From: Sue Howell
Sent: 22 October 2015 17:28
To: Planning.Responses
Cc: Ismail Mohammed
Subject: RE: Planning Consultation on: A/131/15/RES

Comment from Greenspace

Description of Works: Application for approval of Reserved Matters following Outline Approval of Hybrid Application A/125/13 for the development of the site to provide up to 3365 sqm A1 retail use (including parking). Reserved matters consent is being sought for Appearance, Landscaping, Layout and Scale. Departure from the Development Plan. Also within the parish of Rustington.

scheme: Mill Lane Site
client: Store Property
drawing: Landscape Proposals
date: July '15
scale: 1:200@A1
drawing no: STORE18832 18H
drawn: DKM checked: AE

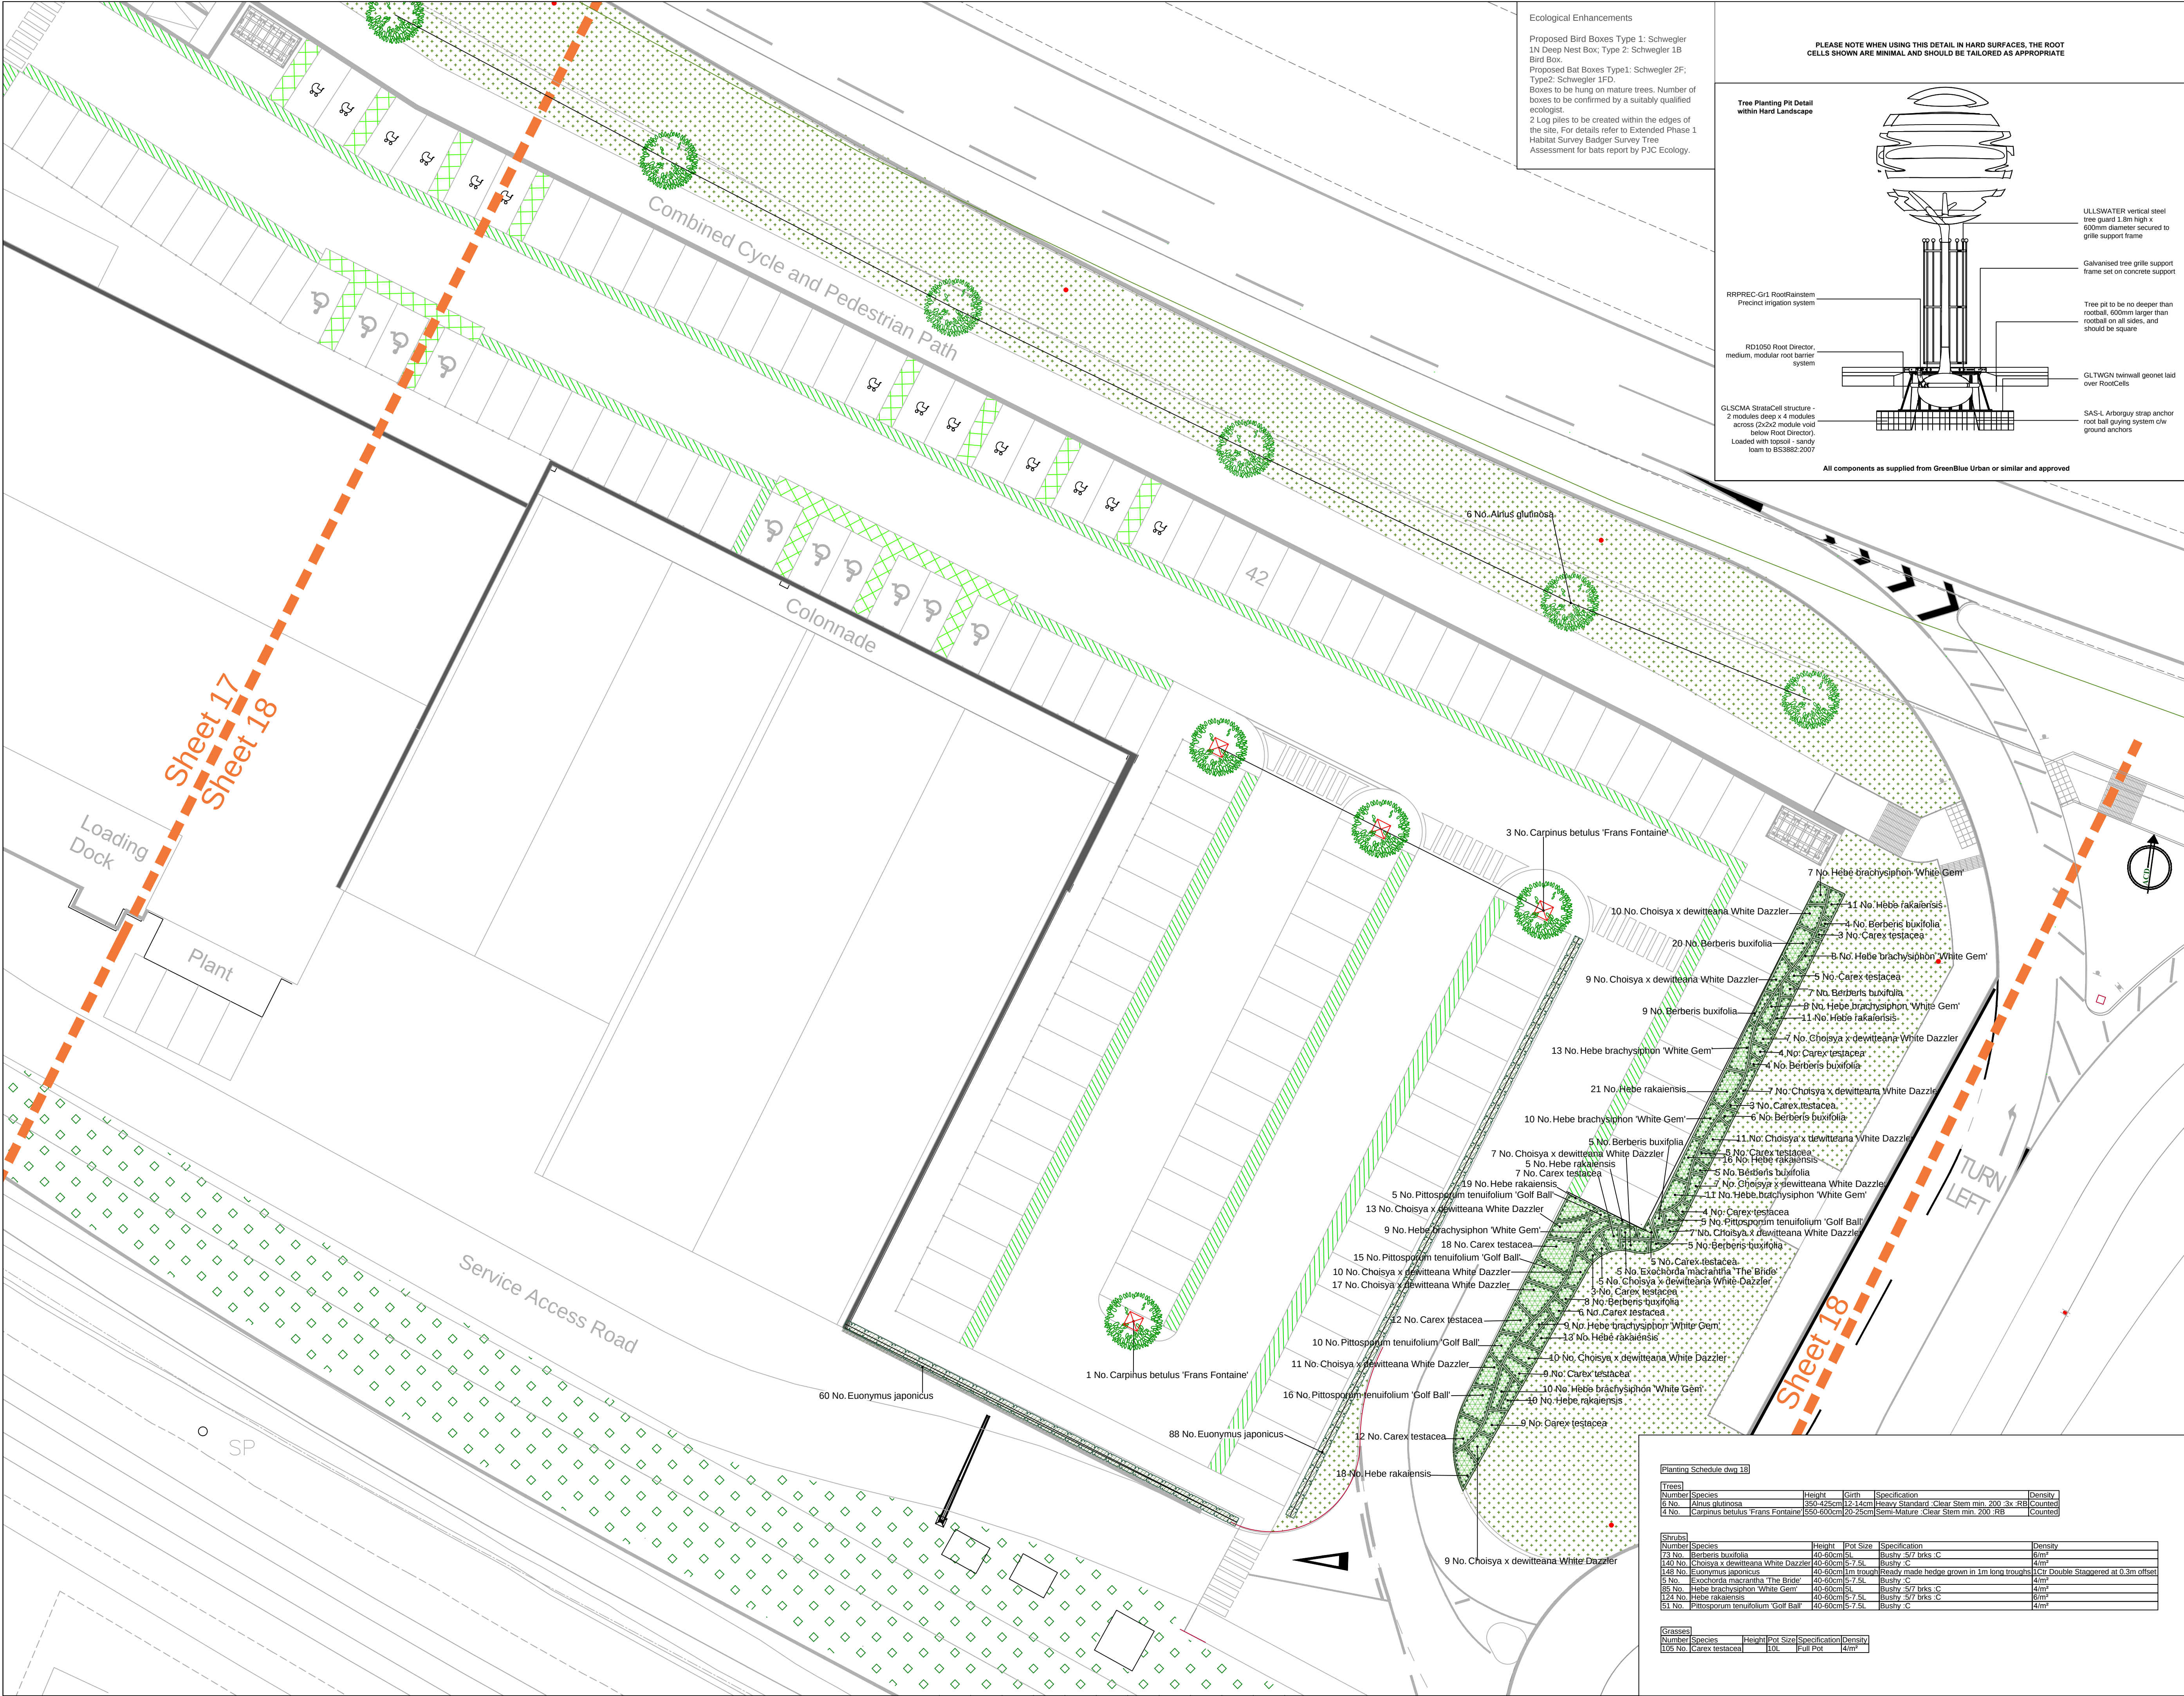
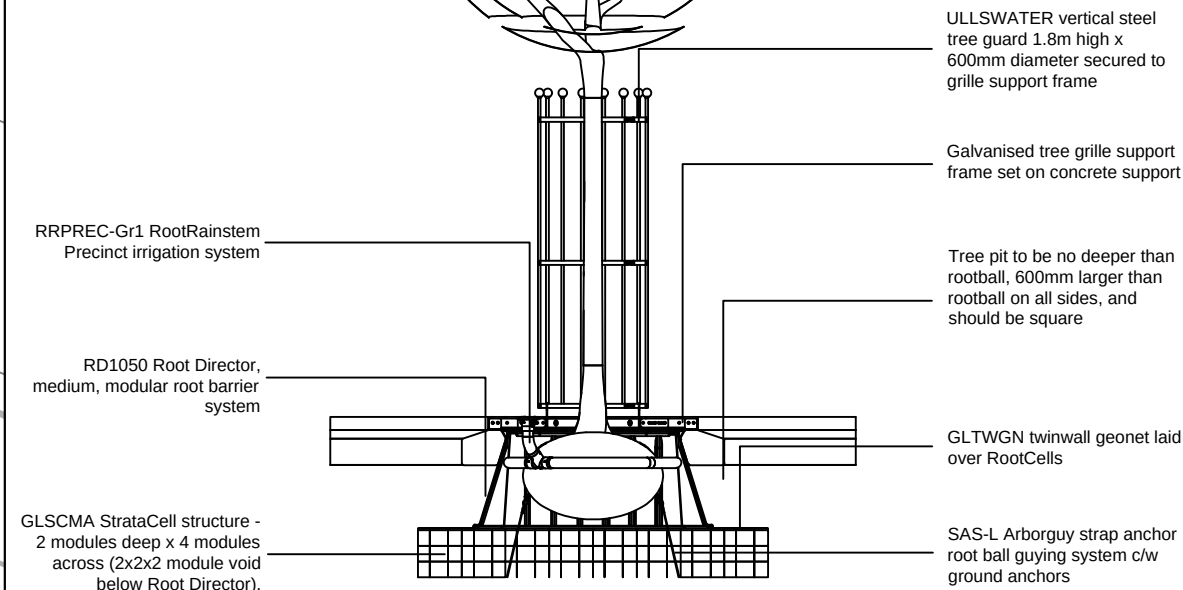
Further to the submission of landscape design details 18832 17H and 18832 18H we have assessed the proposals in conjunction with the original approved outline application A/125/13. The detail now submitted for approval differs substantially from the original and is considerably more sparse than originally indicated. Particularly the trees indicated to be included within the outline application have not been included within this submitted scheme. Significant numbers of new trees were indicated to both the rear and the road frontage areas where now an insufficient scheme is proposed.

I would therefore **not recommend** that these reserve matters are approved until a full scheme more in line with the original application is submitted and approved.
